**RE: Environmental Assessment - Proposed Googong Township Water Cycle Project – Part 3A
*Environmental Planning & Assessment Act 1979***

Googong Township - Water Cycle Project – Environmental Assessment

Department of Environment, Climate Change & Water (NSW) – Comments – December 2010

Figure 11.3 Threatened flora and fauna protection measures

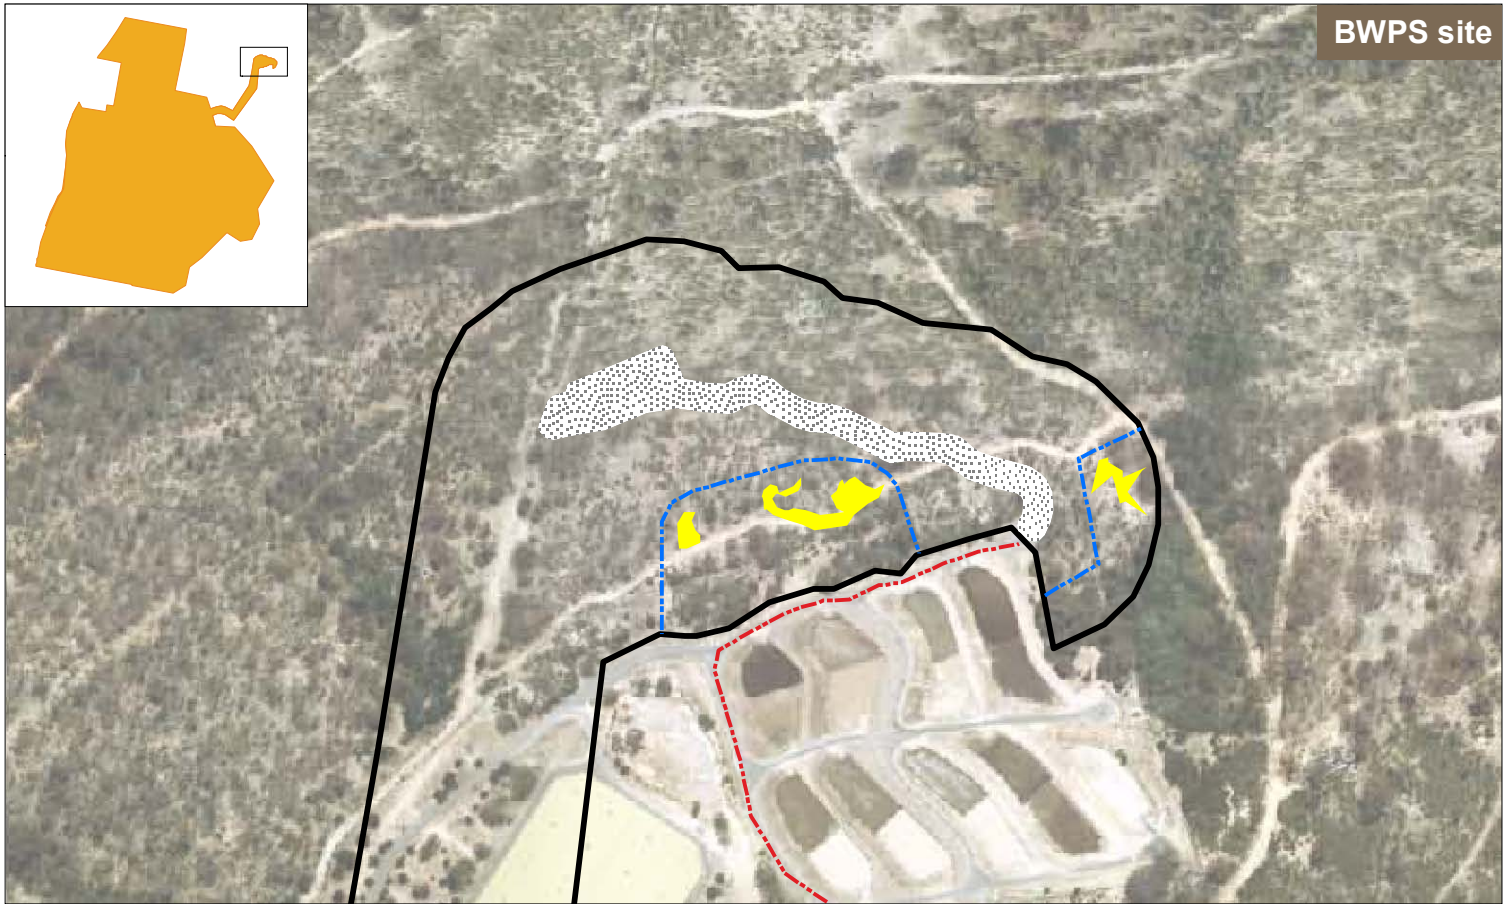
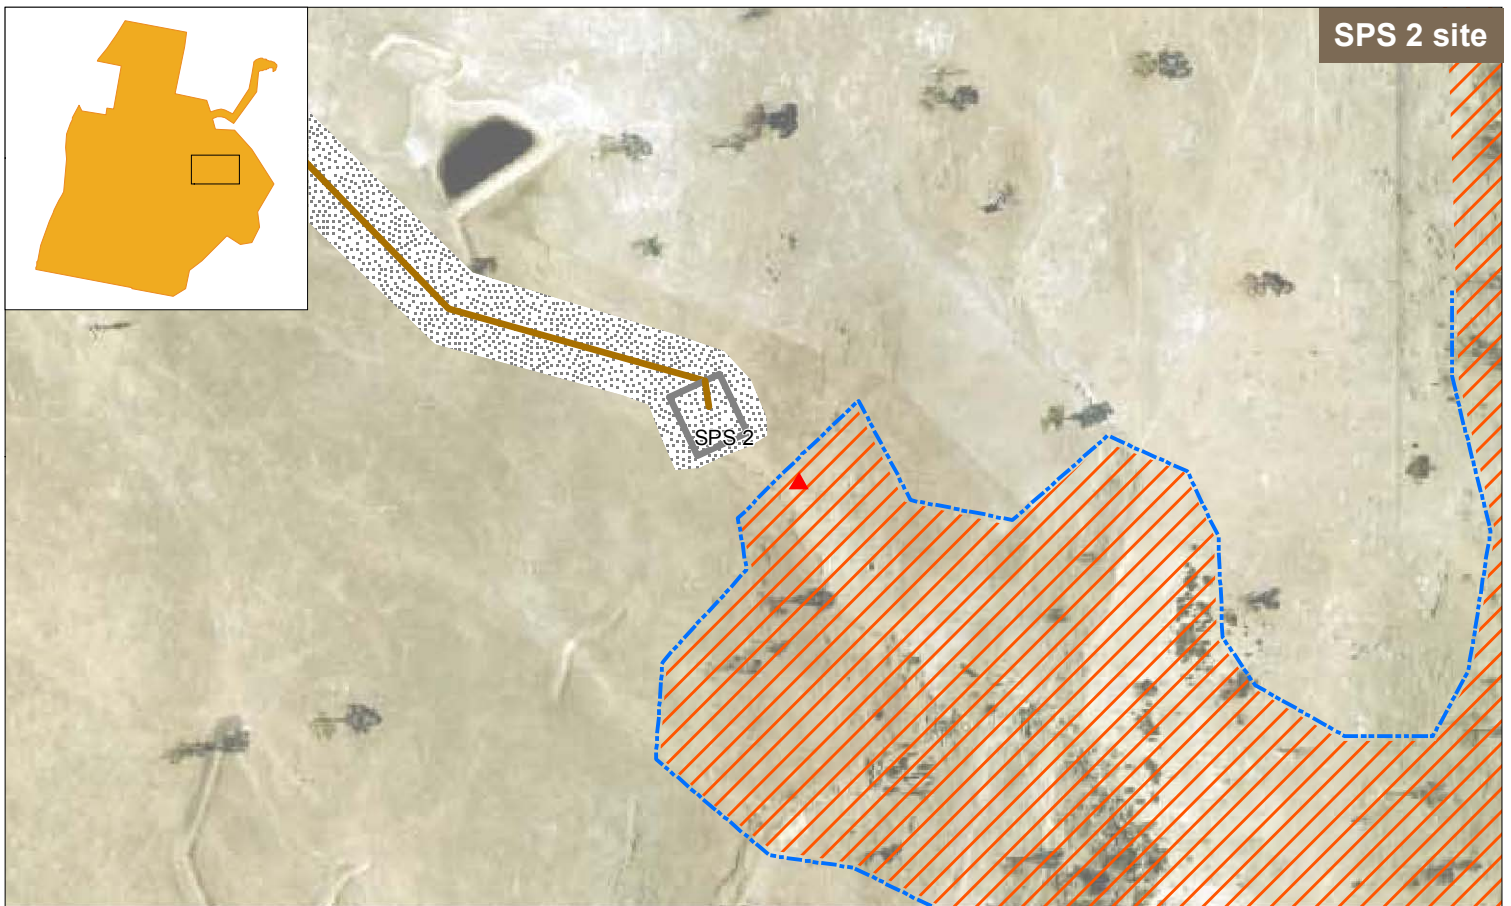
Sewage Pumping Station (SPS 2) is proposed to be located within 30 metres of a Pink-tailed Legless Lizard (*Aprasia parapulchella*) record and habitat. It is possible that this pump station could fail as it is designed to contain a minimum of four hours of peak dry weather flows of sewage. The pump station is located upslope of the known habitat of the Pink-tailed legless lizard.

DECCW is concerned that adverse impacts on the Pink-tailed Legless Lizard, and its habitat in that location, could be caused by overflows from the sewage pumping station. If overflows occur on a periodic basis (ie. during significant rainfall events) it is expected, over time, that the vegetation composition this species requires will be lost and replaced by nutrient loving weeds. To prevent any adverse impact on the Pink-tailed Legless Lizard habitat in the catchment around SPS 2, DECCW recommends that any potential for overflow of SPS 2 be eliminated. Measures to achieve this could include any combination of;

- Back-up pumps and uninterruptible power supply;
- Specifically design SPS 2 to contain a greater amount of sewage in the event of pump failure or power outages (eg. 24 hours average dry weather flows). This extended capacity could allow adequate time for back-up pumps or power sources to be sourced and installed;
- Physical measures to divert and capture any untreated sewage overflows from SPS2.

Figure 6: Part of project (NH1A) wastewater system

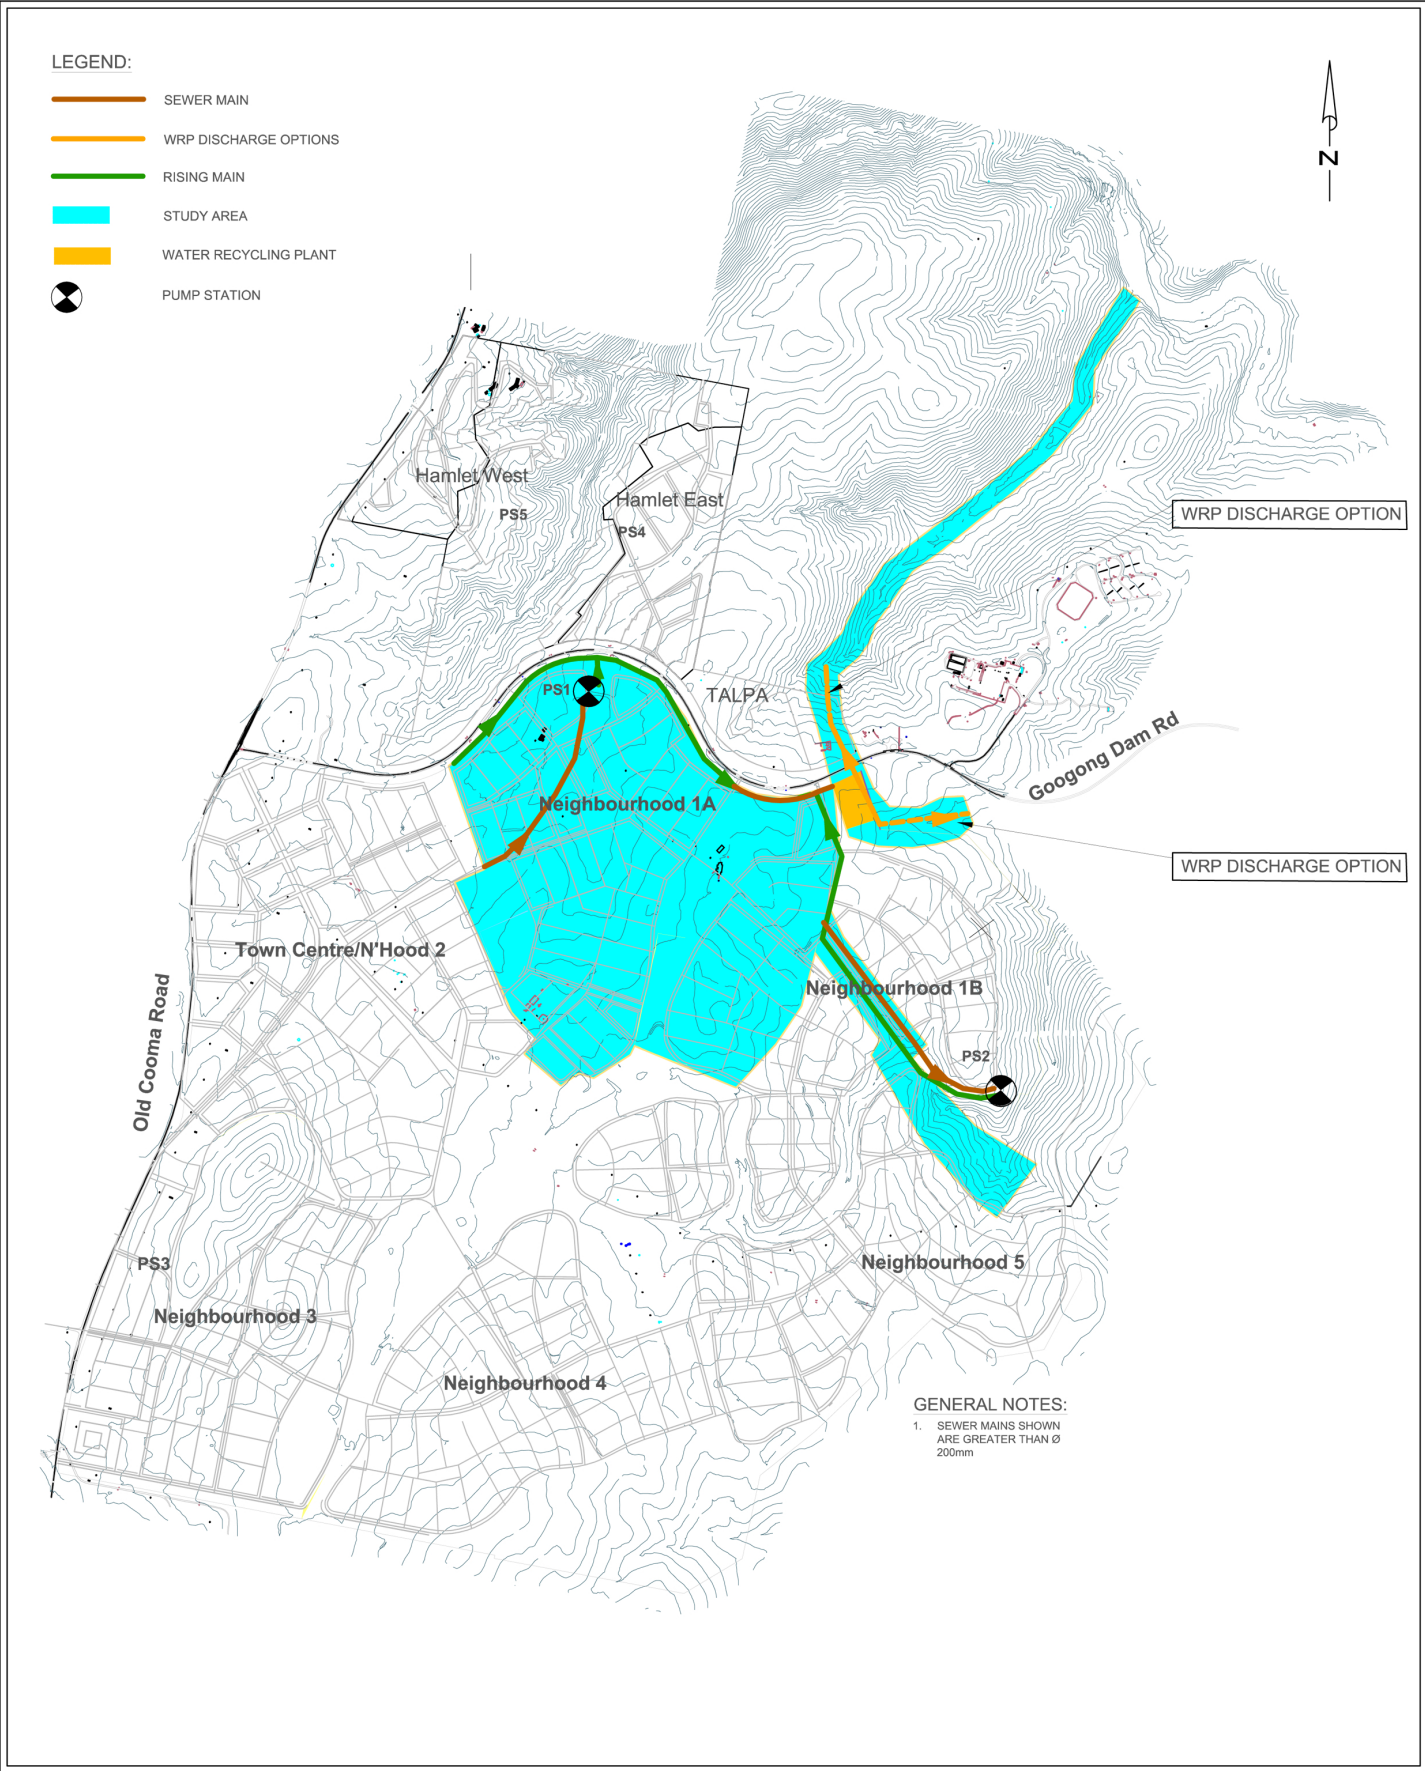
An emergency bypass system for the sewage treatment plant is also proposed which discharges to Montgomery Creek. The capacity of sewage treatment plant is 3.5 times average dry weather flows before discharge of primary treated sewage to Montgomery Creek. Each sewage pumping station is proposed to have a minimum of 4 hours of peak dry weather flow as emergency storage in the event of pump or power failure.
